Subject: CM/44/20/DOC - Land adjacent to Scyld

The submitted Construction Management Plan is not acceptable in its current form. I require the following additional details:

Site Compound
Plan Sheet 2 of 3

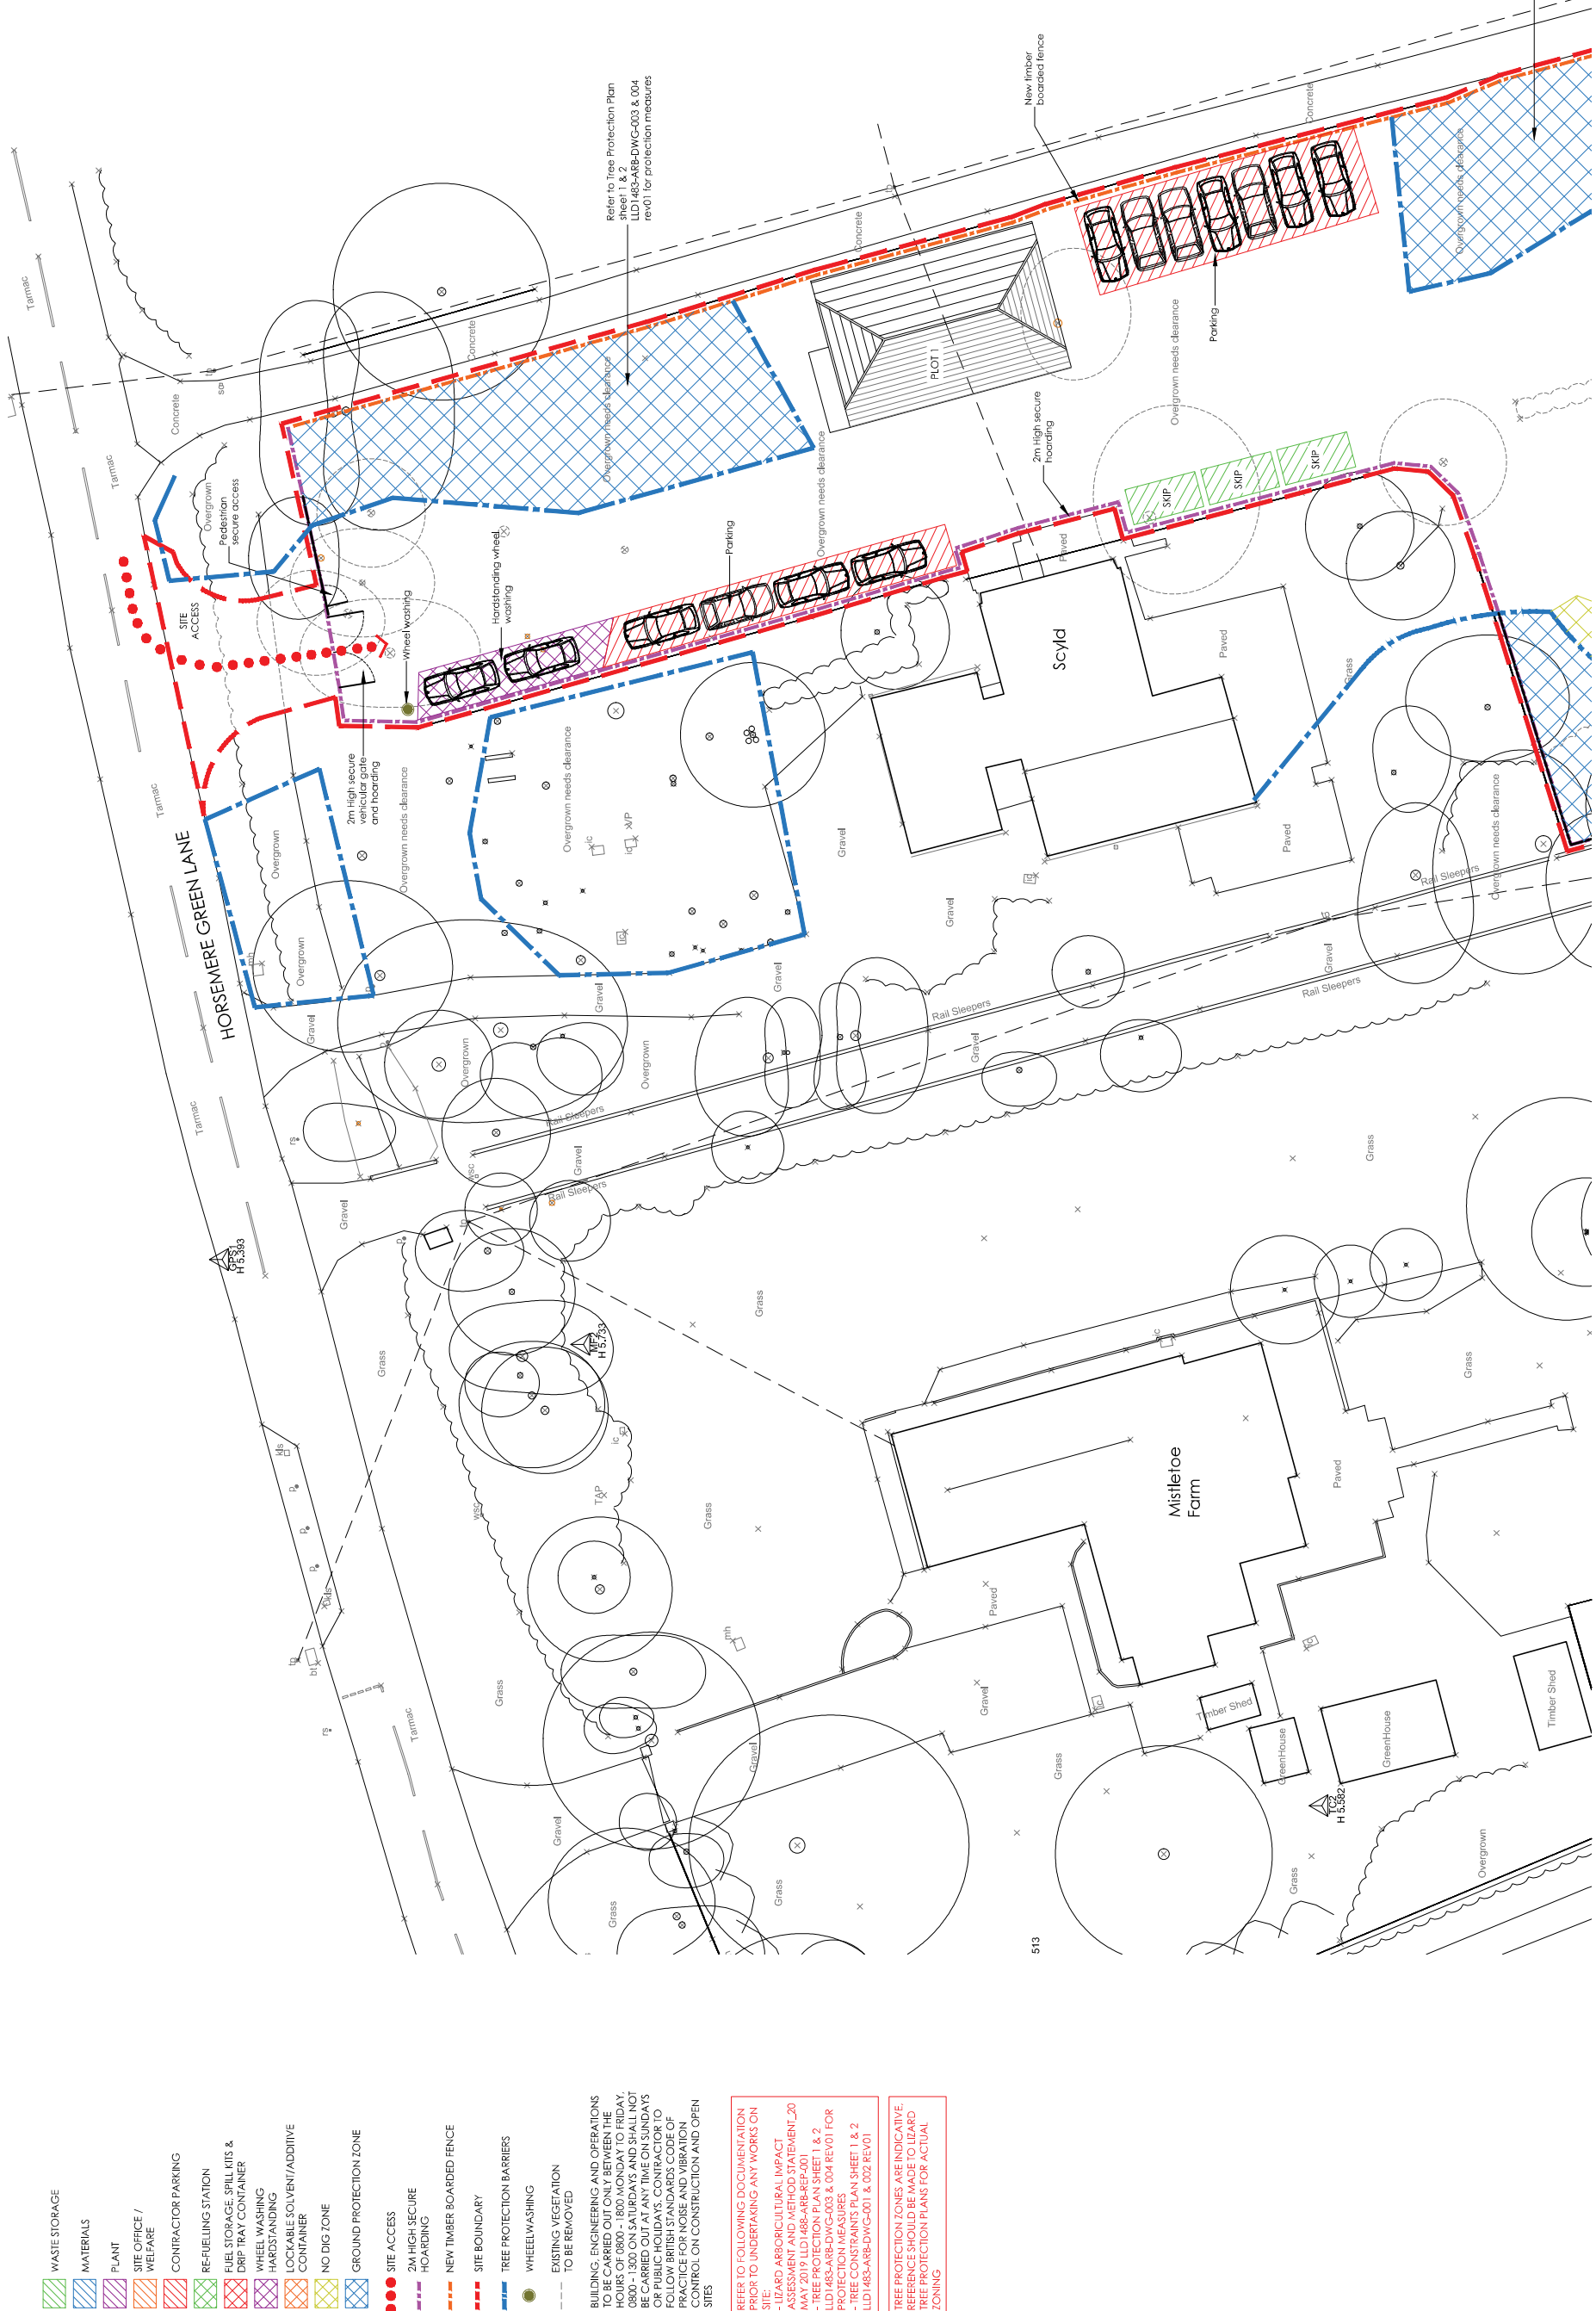
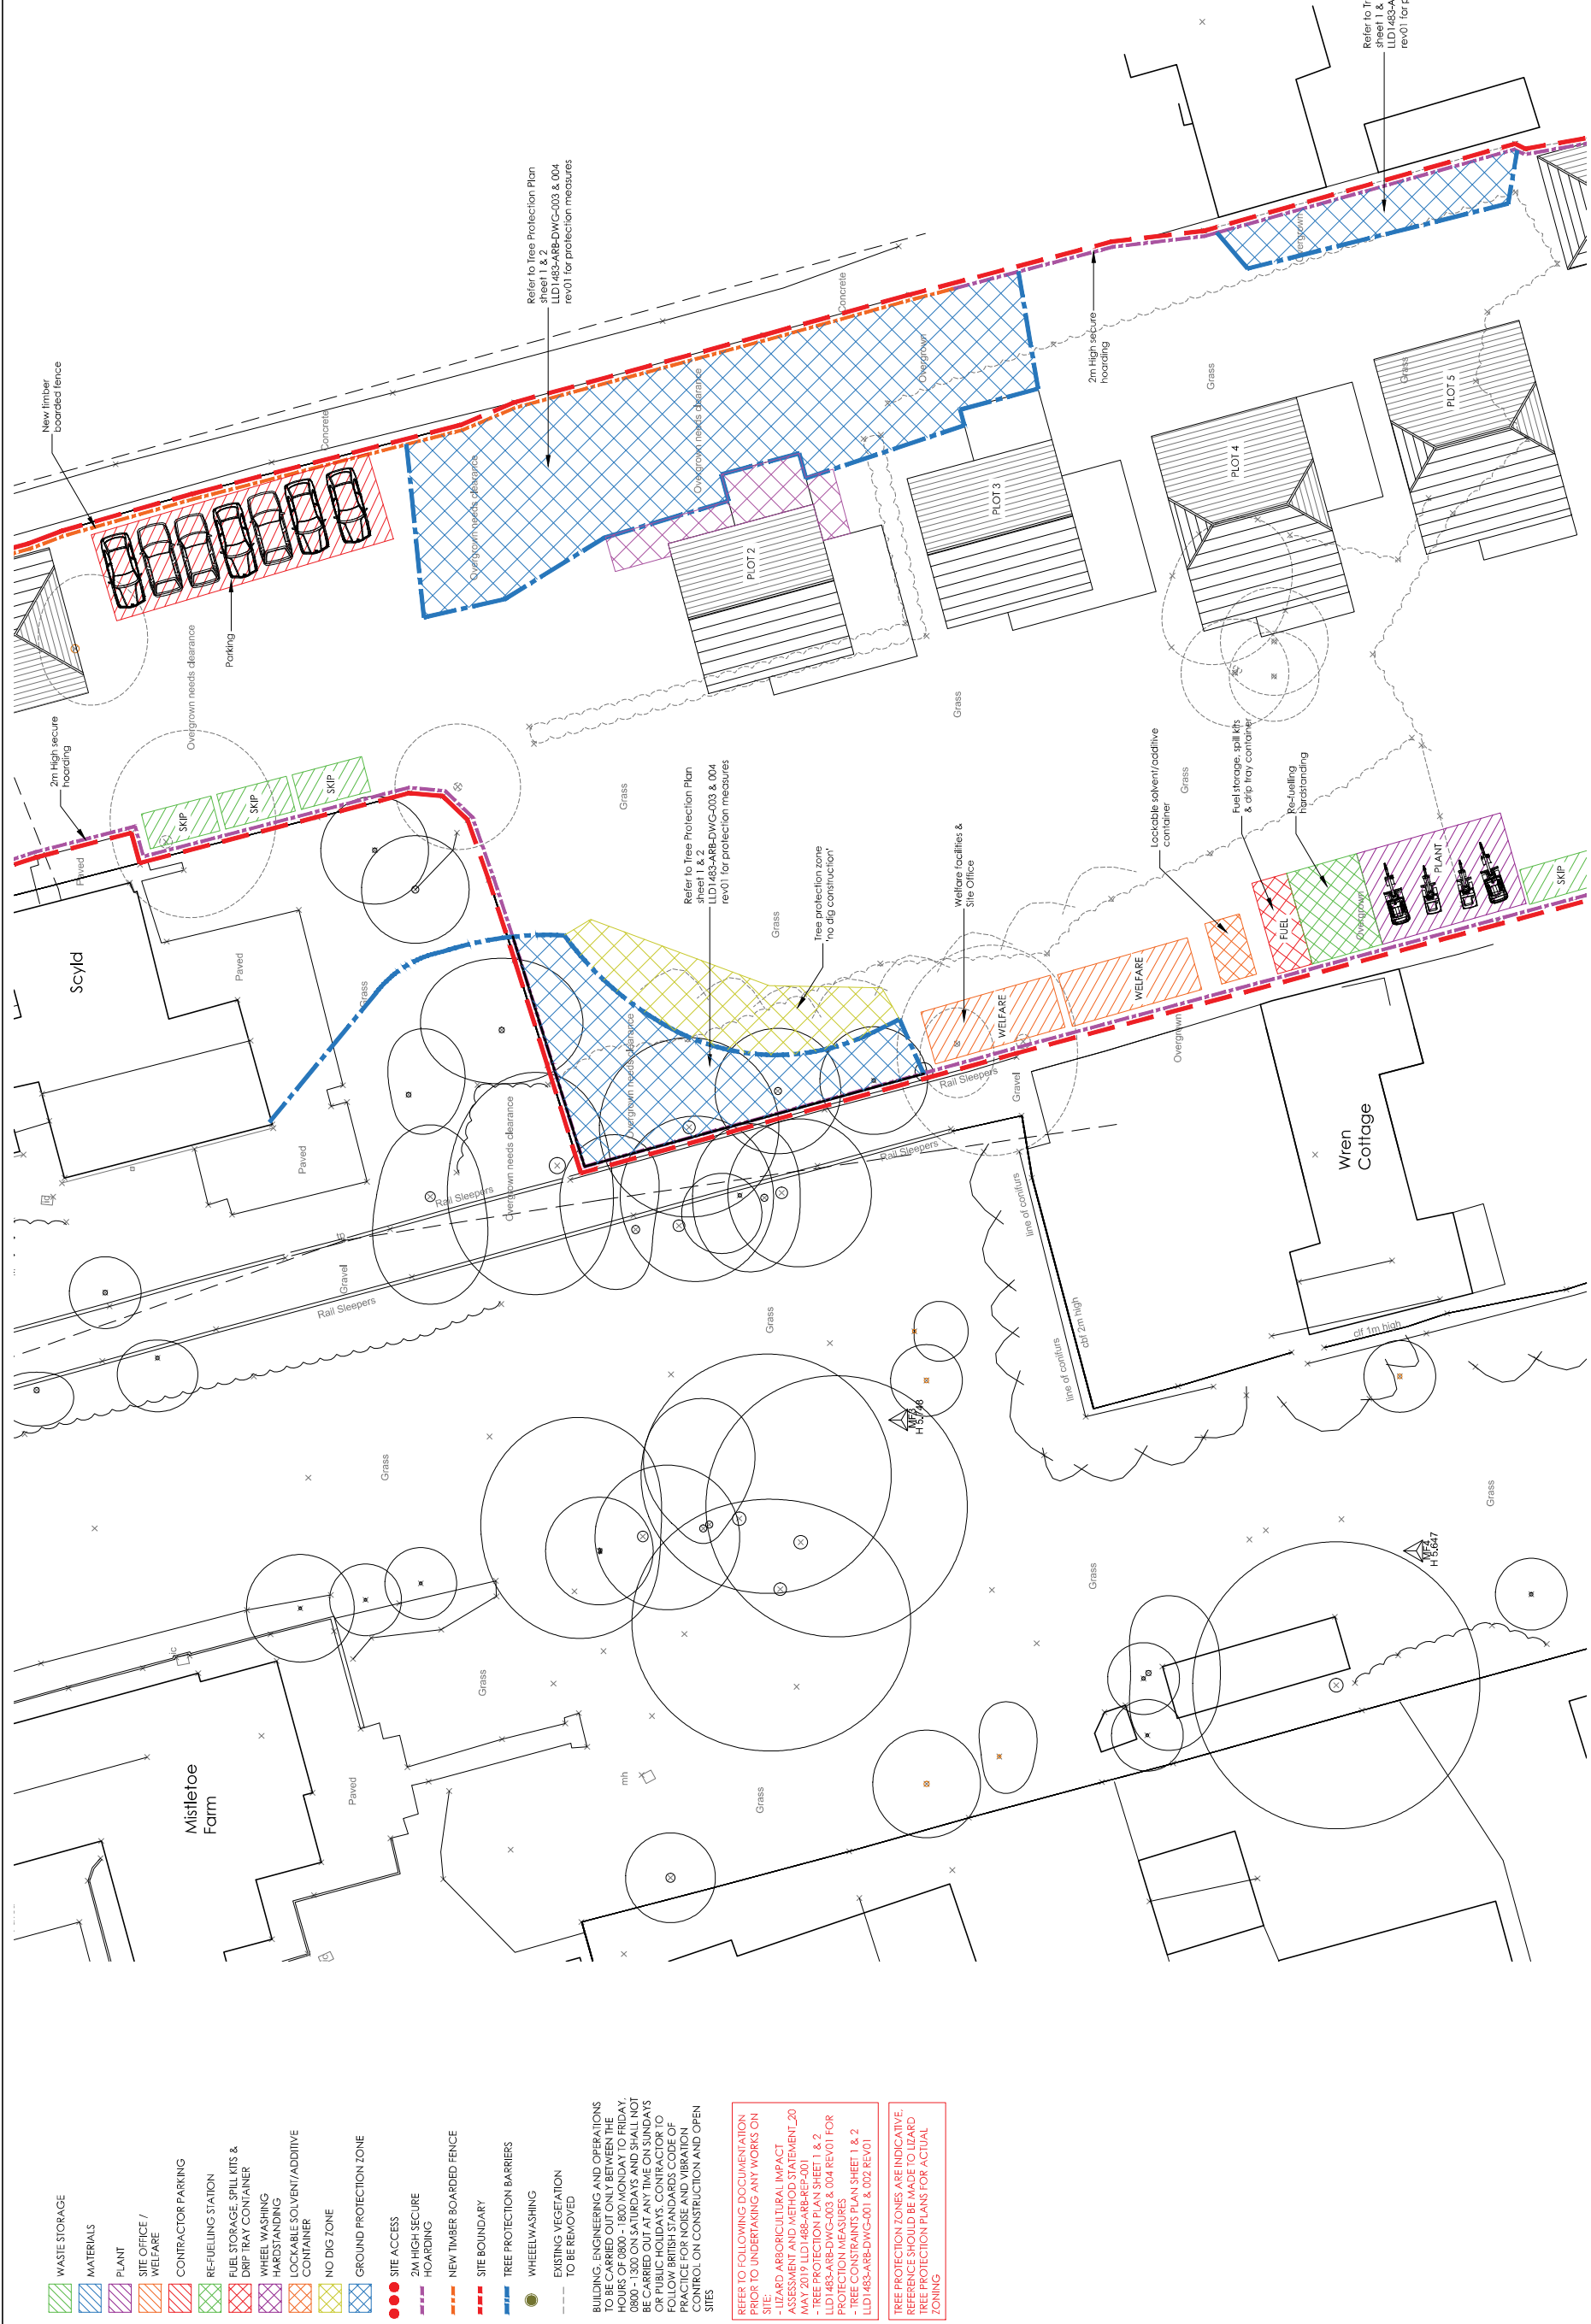
- Confirmation of delivery times - Deliveries will be 8AM - 3.30PM
- Confirmation of hours of operation which should be no greater than 8am to 6pm Mon – Fri and 8am to 1pm Saturday. – Yes confirmed, this is already indicated on the appendix plans series 1111-1113

- Security Arrangements – who will hold the key for the site? - Site Manager
- It is noted that 'debris and mud will not be permitted to enter the access road or public highway', however the road sweeping commentary states it will 'take place on a regular basis to minimise spread of debris on the internal road network' – will there be any cleansing measures for Horsemere Green Lane in the event that mud/debris were to enter the road? -Wheel wash will be in place at the entrance as shown on the CMP drawing series 1111-1113 & hire purchase will be set up for road sweeping as and when necessary.
